RFI # 200

Date: 10/22/2012
 Job: EB-02 Keller Springs Floors
 Phone: 877-777-9115

Subject: B2 Part 4 unit Columns and patio dimensions

Drawing: 2.7A, 3.1C, 3.2C, 3.4C, S2.23, S2.33, S2.43

SHEET NUMBER
3.1C
BLDG PLAN 'C'

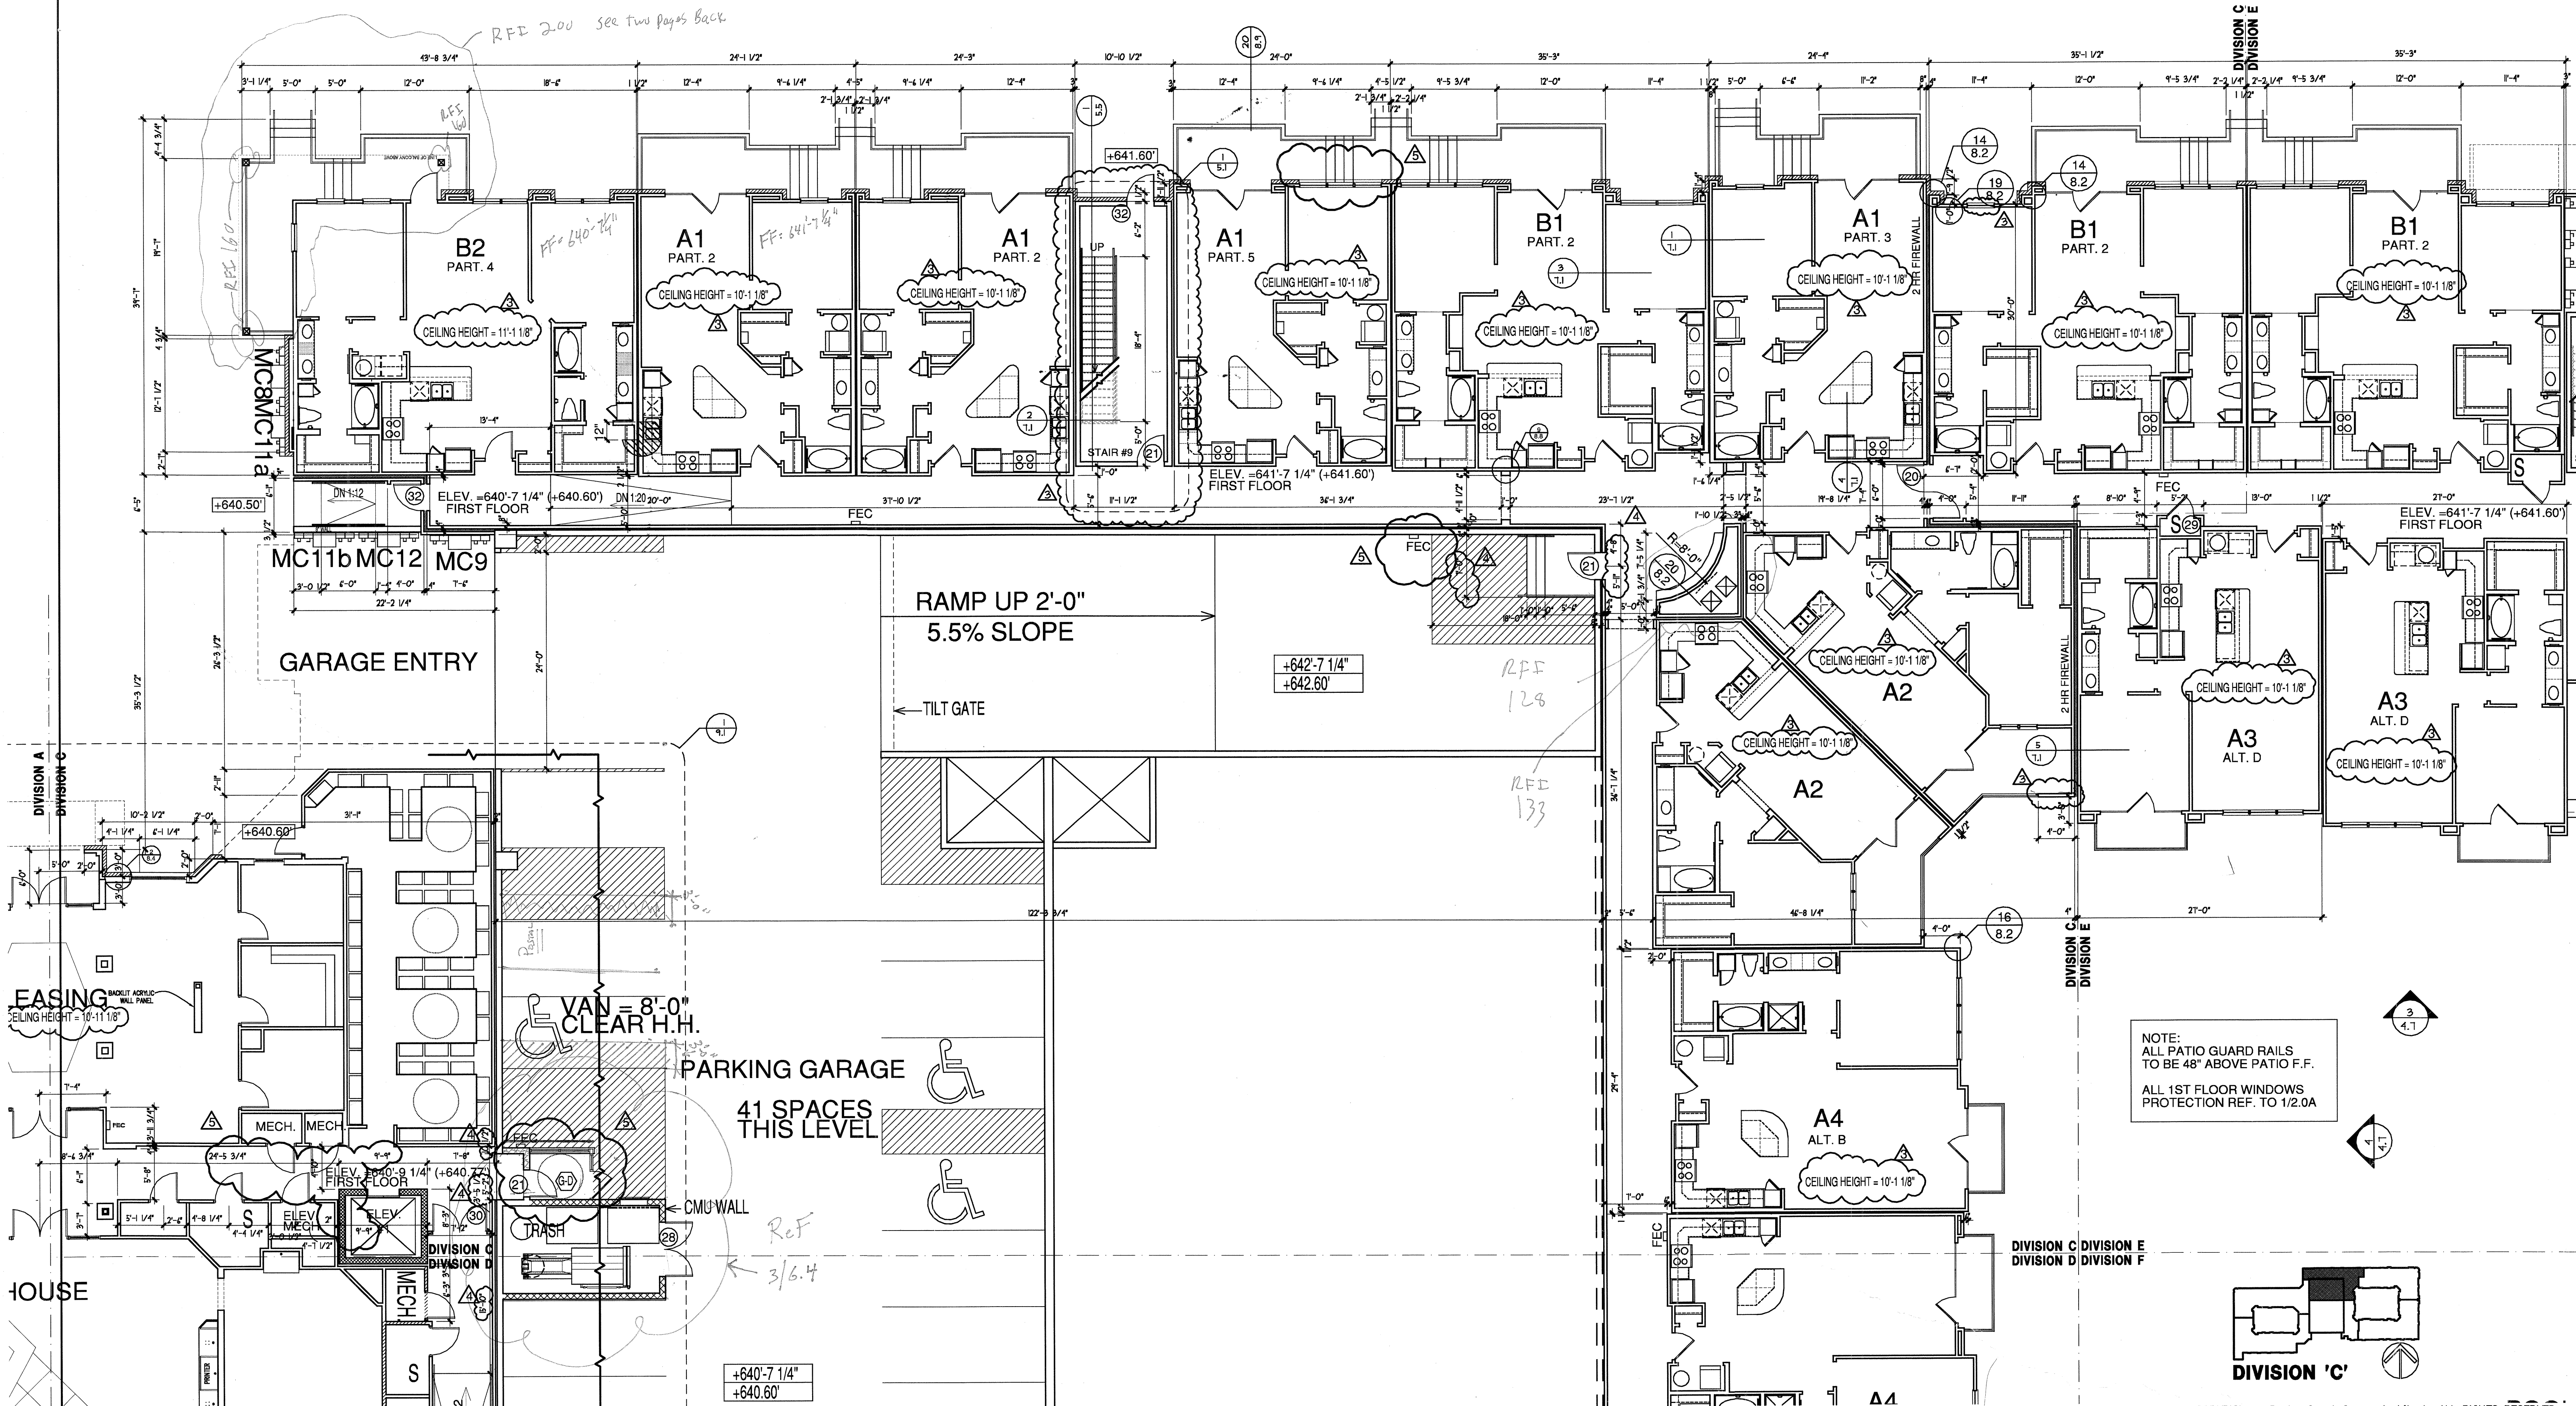
Request: The attached RFI from Red River Framing is in reference to the B2 Part 4 unit columns and patio dimensions on Z/2.7A vs. the B2 Part 1 unit balconies above shown on 1/2.7A. The B3 Partial 1 units show the supporting walls 6" past the support columns from the B2 Part 4 units. Please review and advise.
 Date Required: 10/24/2012

PPO takes no exception to the cantilevered truss solution proposed below.

BGO suggests cantilevering the trusses for these B2 units in question as shown in the next pages of this PDF only if the Trusses are signed and sealed by an engineer in the state of Texas.
